Our ref: **INVALID APPLICATION ACKNOWLEDGEMENT**
GCC Application Ref: **21/02414/LBA**

SITE: 1 Westbourne Gardens Glasgow G12 9XQ

PROPOSAL: Installation of replacement windows and removal of security bars

ELEVATION DRAWING

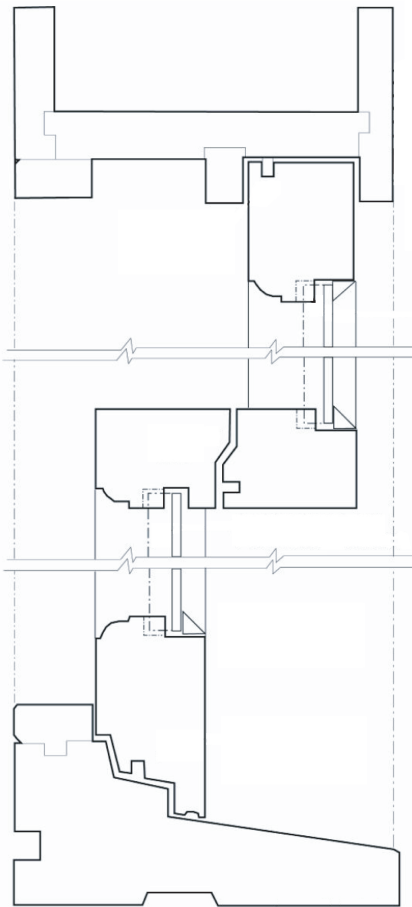
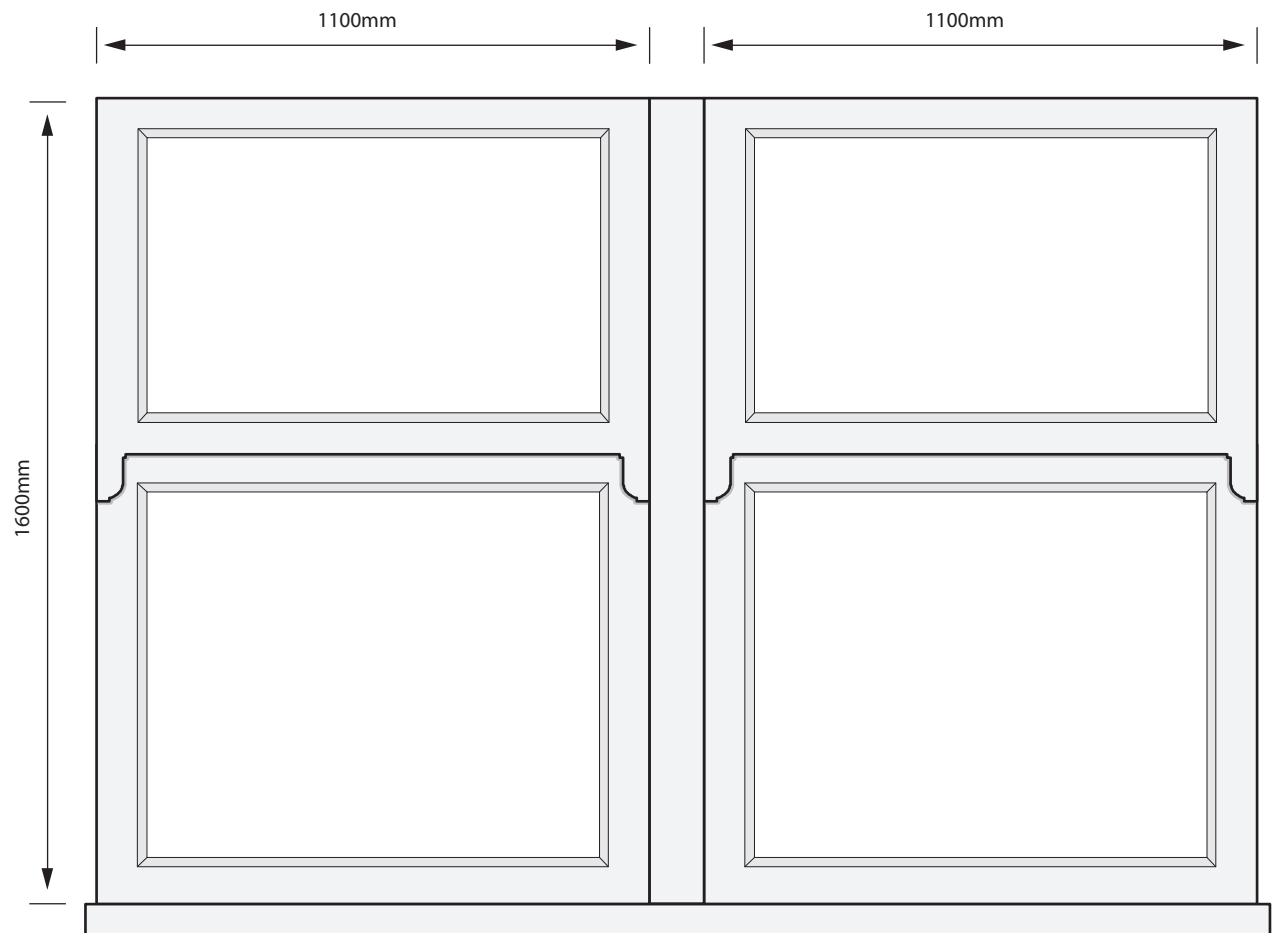
001 In order to assess the proposal, please provide a window schedule showing dimensions of all windows to be replaced. Please include details of windows astragal bars/horns etc.as applicable. Please provide full scaled drawings with a scale and scale bar of the elevations with the windows annotated to correspond with the window schedule. We must be able to link the schedule to the drawings/photographs provided.
